Martin Nugent
01254 828060
D3/11/0776

15 NOV 2011

**Outline Planning Application, Ribble Valley District
3/11/0776 land at Whiteacre Lane, Barrow, Wiswell**

Development Proposal - Opt B
(7 No. Residential Dwellings)

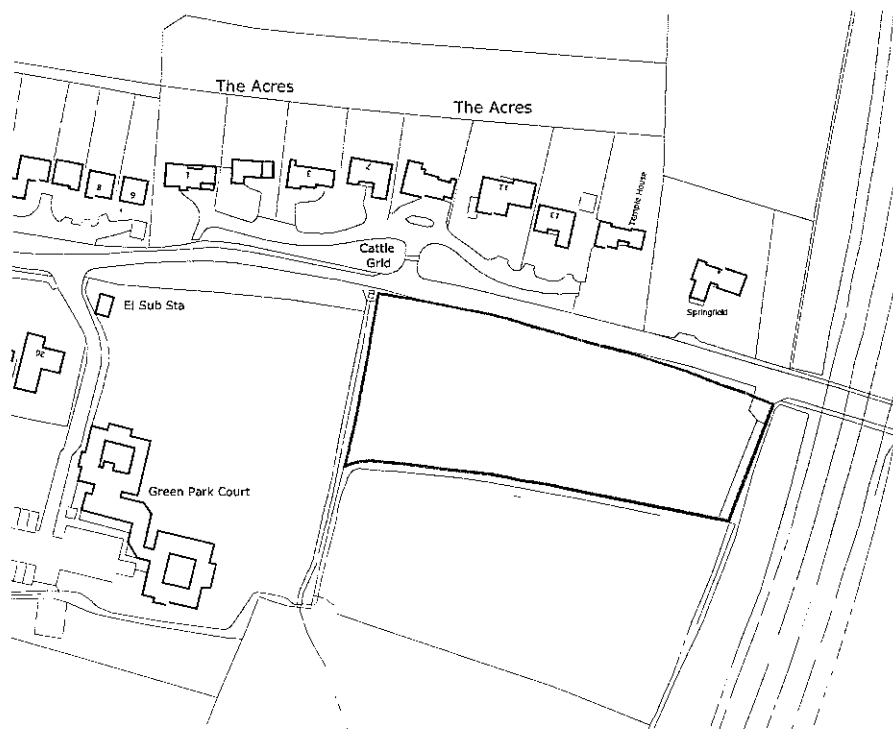
A total of nineteen car parking spaces are indicated for the proposed parking provisions for the seven dwellings; five for market sale and two affordable units. This is consistent with five 3-bed and two 2-bed units and represents a satisfactory level of provision.

For a relatively lightly trafficked road of this type with a 30mph Speed Limit in operation, I am satisfied that a new access point onto the highway should provide a 2.4 metre x 60 metre visibility splay in both directions, as recommended in Manual for Streets 2.

The Applicant has located the proposed new access towards the north west corner of the site and directly opposite the entrance to The Acres. While this has maximised the easterly sightline, it has resulted in the westerly visibility splay extending across land not shown to be within an area directly under the Applicant's control. I would welcome confirmation that the Applicant has a relevant third party agreement in place or can demonstrate that the land is otherwise available for inclusion in this visibility splay.

In terms of pedestrian access there is no footway shown to the west of the site. However, in creating the appropriate conditions to satisfy the 2.4m by 60m visibility splay, a substantial area of verge along the south side of Whiteacre Lane will have to be cleared and maintained at a suitable level. I would recommend that this provides an opportunity to introduce a footway, approximately 100m in length that would link with the existing pedestrian facilities that front properties from No.26 Whiteacre Lane.

I recognise that the layout of the access to the site has been designed to encourage low speeds of approach from Whiteacre Lane and within the limits of the development. However, in view of the very short lead in distance from Whiteacre Lane and the severity of the turn into the service road, I would recommend that the carriageway width be increased to 5.5m and that this is maintained for a minimum of 5m into the site. This will allow an emerging vehicle to be stationary at the junction, while another vehicle can manoeuvre into the site.

The Applicant has clearly identified that where it is proposed to alter the line of existing hedgerows these will be replaced to the back of the revised visibility splays.

In order to maintain and improve compliance with the existing 30mph Speed Limit on this length of Whiteacre Lane, gateway markings should be introduced at the transition point to the east of the site. These will consist of a series of red bar markings and a painted 30 roundel. I would have no objection if the precise location and design of this feature was to be agreed as one of the subsequent Reserved Matters.

- 1 Confirmation that the Applicant has a relevant third party agreement in place or can demonstrate that the land to the west of the site that falls within the 2.4m by 60m visibility splay is otherwise available for inclusion.
- 2 The provision of a new length of footway, approximately 100m, linking the site with the existing pedestrian facilities that front properties from No.26 Whiteacre Lane.
- 3 Alterations to the design of the site access to provide for a minimum width of 5.5m for a minimum distance of 5m from the back of the edge of carriage before turning into the site.
- 4 The inclusion of gateway markings at the Speed Limit transition point to the east of the site.
